**WELWYN HATFIELD COUNCIL – DEVELOPMENT CONTROL**  
**DELEGATED REPORT**

<b>APPLICATION No:</b>	<b>S6/2009/1438/FP</b>
------------------------	------------------------

The proposed development would involve an extension to the roof space at the rear over an existing single storey extension. A hipped roofed dormer would be added to the front plane of the roof, which would measure 1.5m in width by 2.2m in height. A hipped roofed dormer would also be added to the north western plane of the roof, which would measure 1.5m in width by 2.2m in height.

Scale 1/50 @ A1	Date June 2009	Drawn by NH
Drawing No. NH/354/03	Rev. A

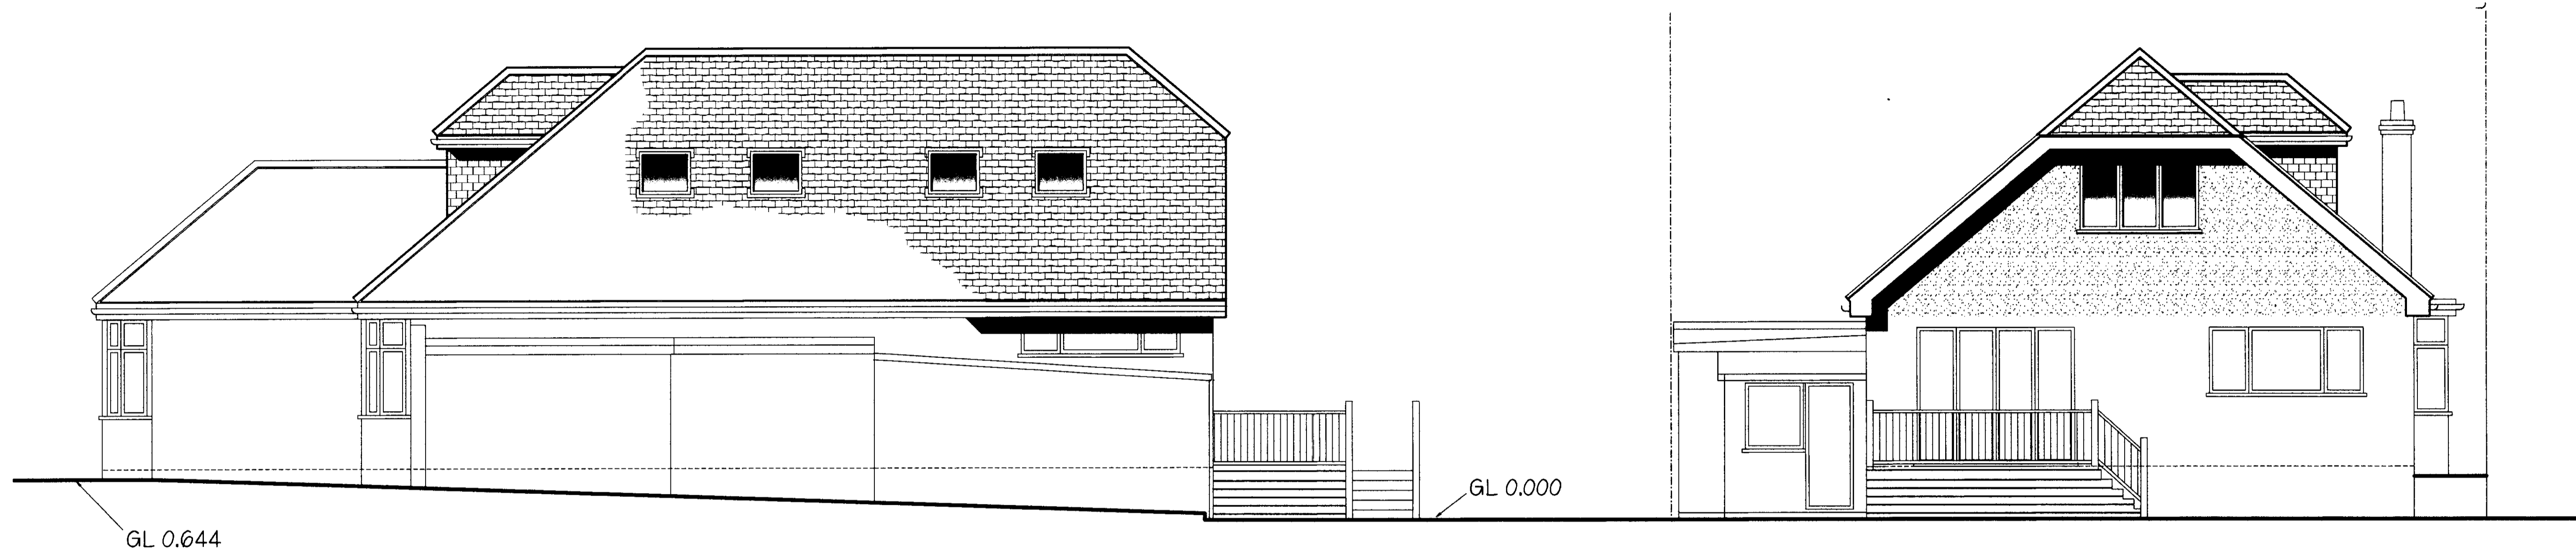
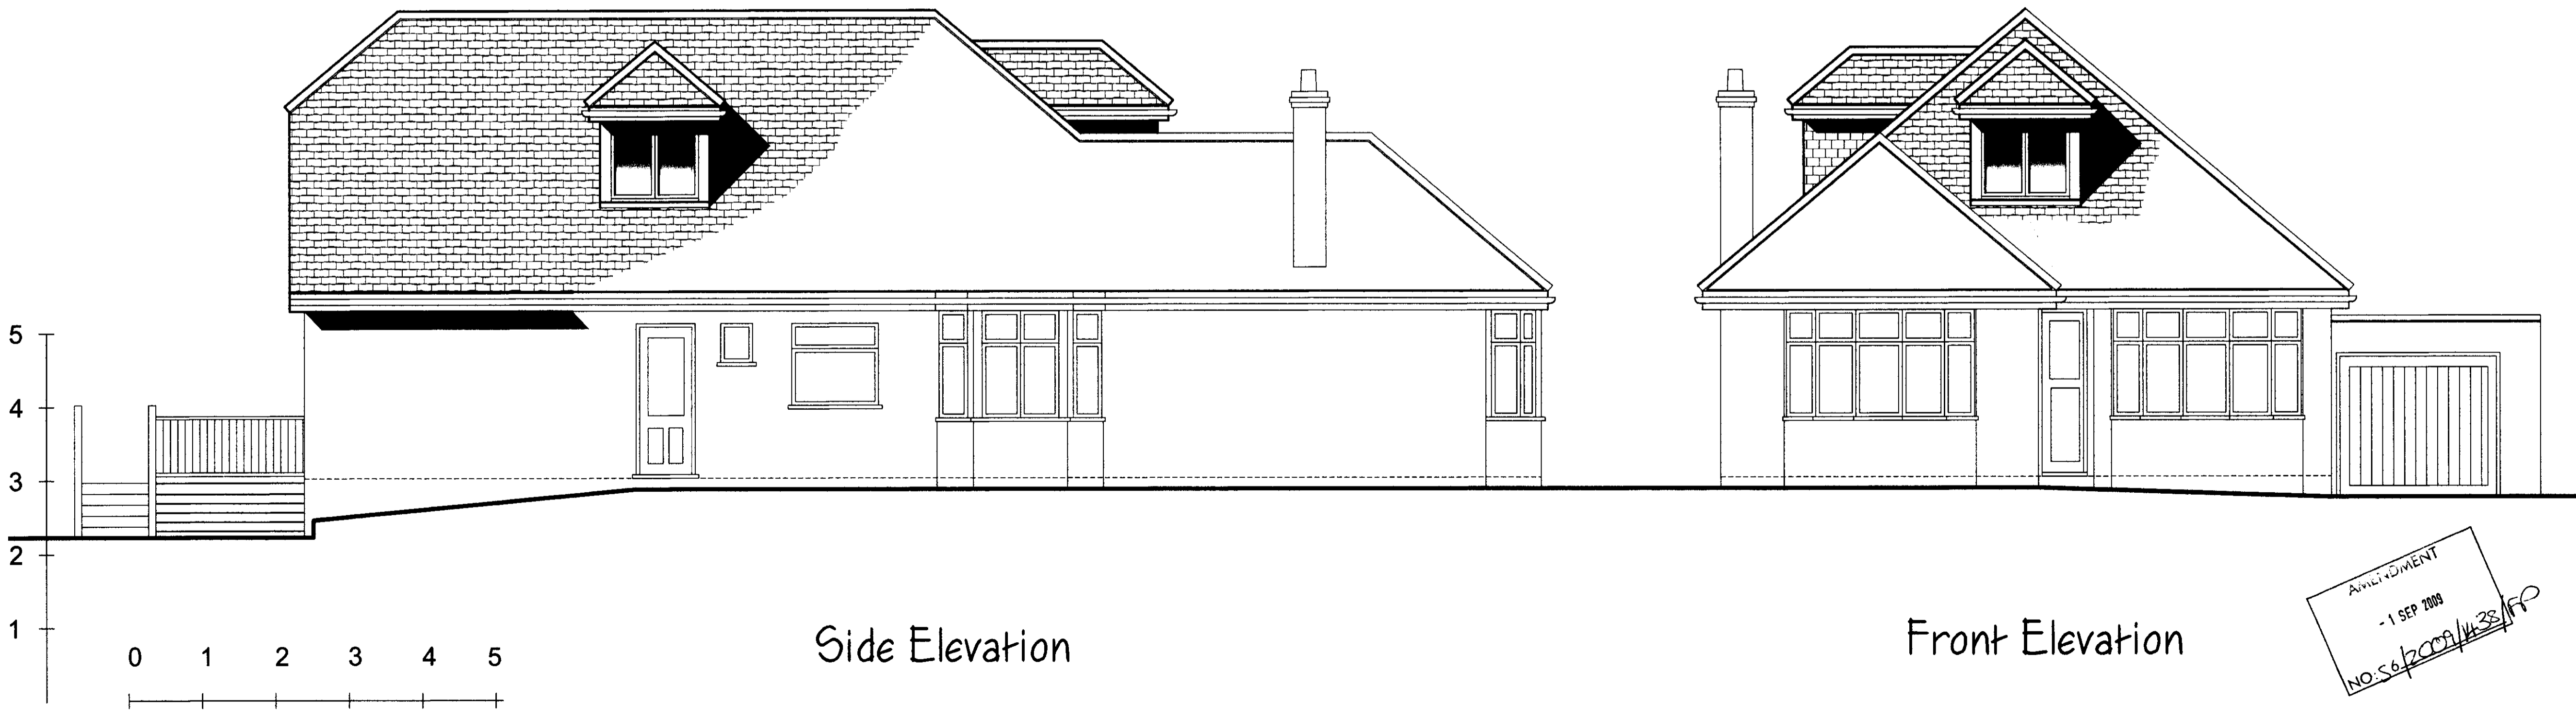
1. The proposed development that would be visible to the front of the dwelling would involve the construction of a hipped roofed dormer to the front and north western side planes of the dwellings main roof. The application dwelling is a similar property to the neighbouring property to the north west (no 48). Both the application dwelling and number 48 have made alterations and the original appearance of number 48 has been changed.

The proposed alterations that would be visible within the public street scene have been designed to reflect the original shape and form of the main dwelling. The surrounding area contains both houses and bungalows and the proposed two-storey appearance would not appear out of place. The proposed front dormer has been amended to be smaller and appear subordinate to the front plane of the main roof. It has been acknowledged that the proposed front dormer would be sited relatively close to the edges of the roof plane. However, it would not appear too large and would retain an appropriate distance from the ridge and eaves of the main roof. When compared to the flat roofed, front dormer that has been constructed to the adjacent dwelling the proposal would have a better appearance and would reflect the original dwelling. The proposed alterations to the garage would not affect the frontage of the dwelling.

The proposed side dormer would be in proportion with the roof slope that it would be constructed on and this addition would not have an adverse affect on the appearance of the dwelling. When compared to the adjacent property, which has a flat roofed side

dormer, the proposal would have a better appearance and respect the character of the dwelling. The proposed side dormer would retain an appropriate distance from the flank boundary of the plot.

The proposed alterations to the rear of the dwelling would not be visible within the public street scene to the front of the dwelling. These alterations would reflect the original appearance of the dwelling and would reflect the original pitch of the main roof. The resultant dwelling would not appear overly dominant from the surrounding area and not have an adverse impact upon the character and appearance of the locality.

The adjacent dwelling to the north west (no 48) is set forward at the rear elevation by roughly 6m. The proposed development would build above the existing single storey rear extension with a dutch gable ended rear elevation. Due to the application dwelling being a relatively low building and both properties being detached, the resultant dwelling would not appear too large or dominant when viewed from number 48. The partly hipped roof would help prevent a loss of light to number 48 and this dwelling would not suffer any significant overshadowing.

The proposal would have one side facing dormer window to the north western plane of the roof and 4 rooflights to the south eastern plane of the roof. To ensure that these would not result in overlooking the dormer could be conditioned to remain obscure glazed and top vent level opening only. To ensure that the velux windows would not result in a loss of privacy they could be conditioned to have a cill height no lower than 1.7m above the internal finished floor level. These conditions would ensure that the development would not result in an adverse loss of privacy to the adjoining occupiers.

Drawing No.
NH/354/02

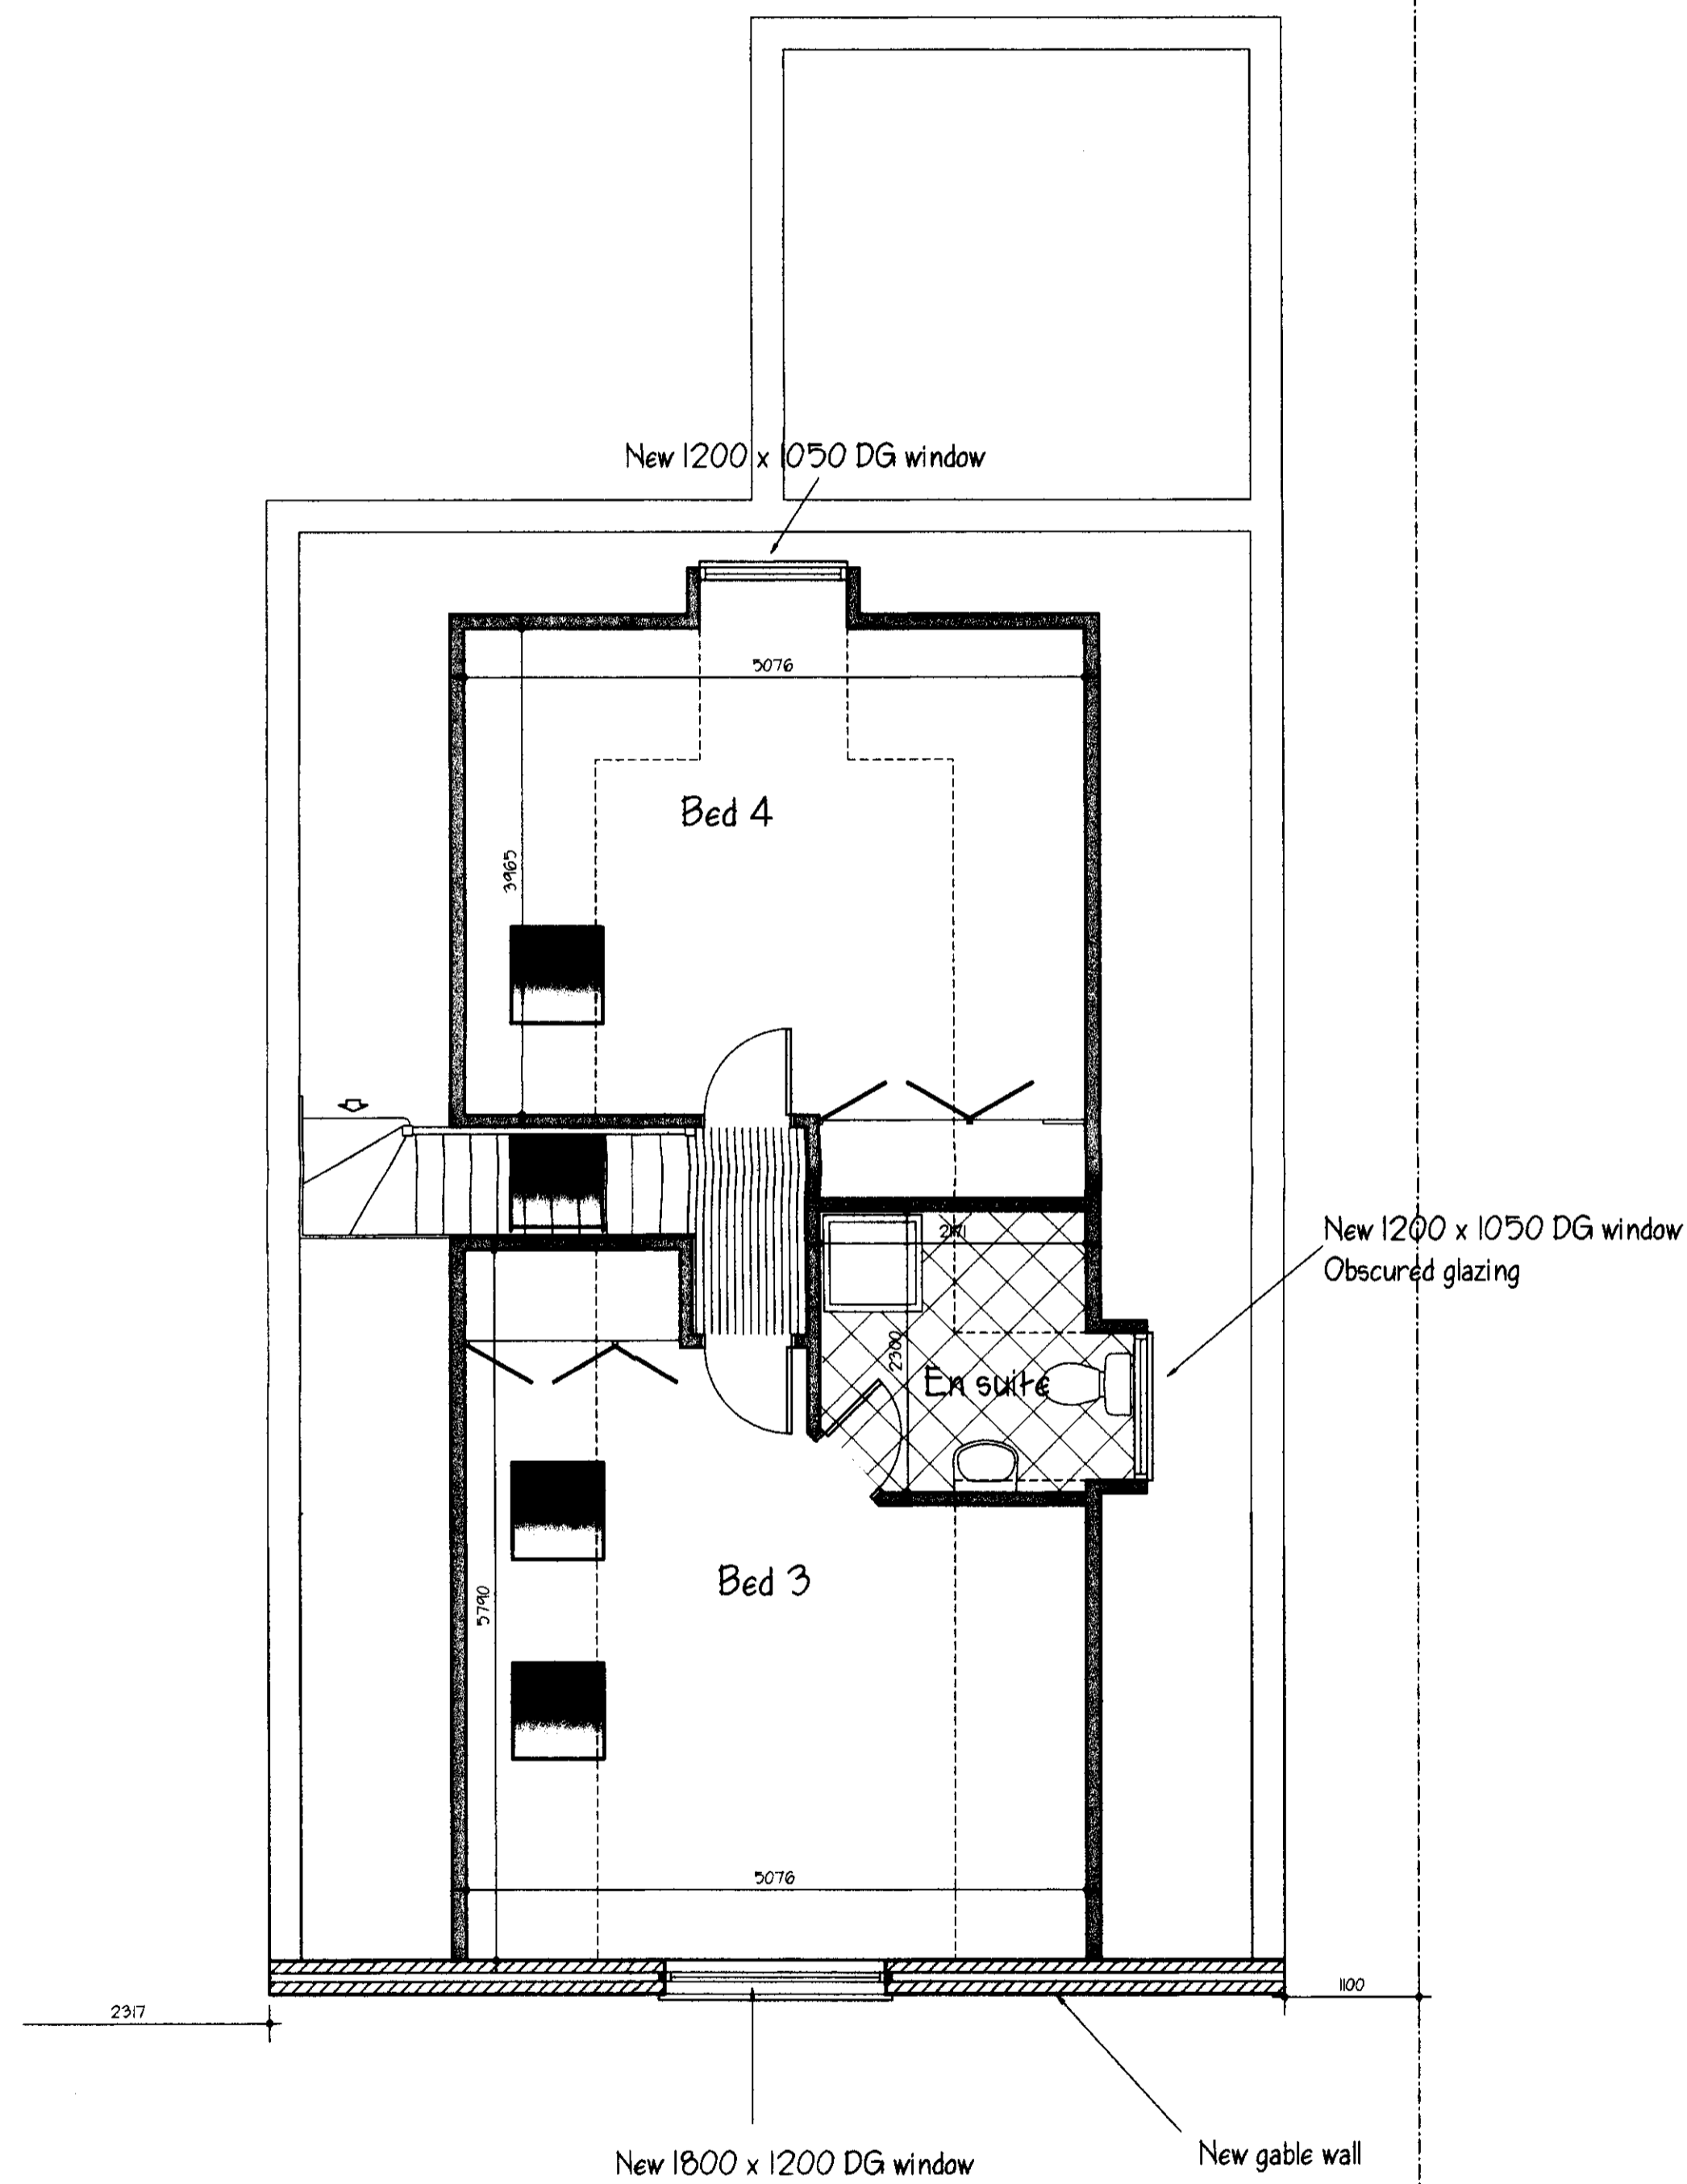
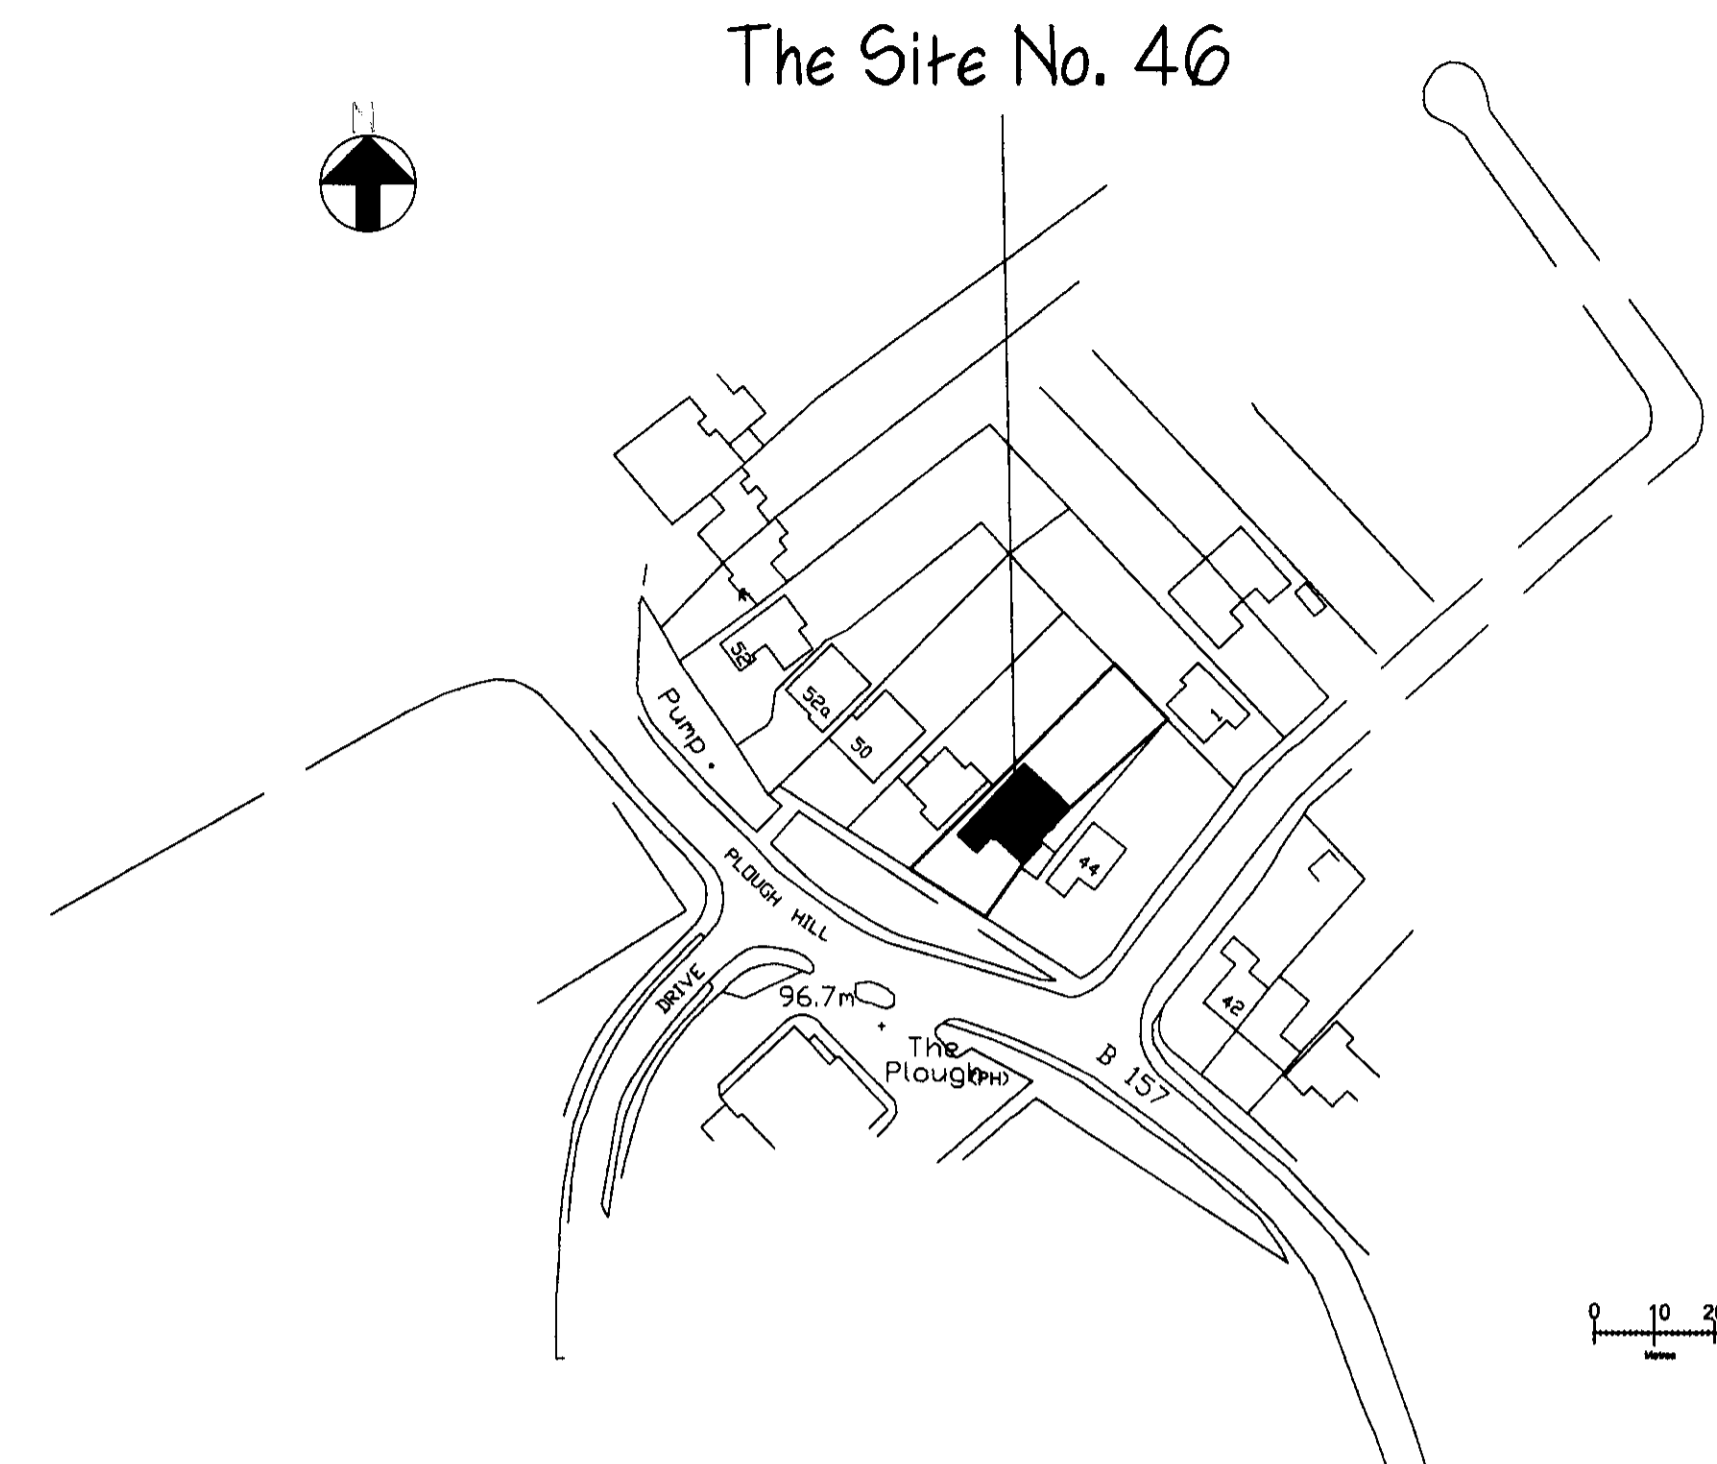
Cuffley is located within Zone 4 as designated within the Supplementary Planning Guidance-Parking Standards. It is specified that a dwelling containing 4+ bedrooms within this location should provide for a maximum of 3 car parking spaces. The application forms state that the car parking arrangements would not be altered and a site visit confirmed that three car parking spaces are available on site to the front of the property, which is considered adequate and in compliance with the revised parking spaces and complies with Policy M14 of the Welwyn Hatfield District Plan 2005.
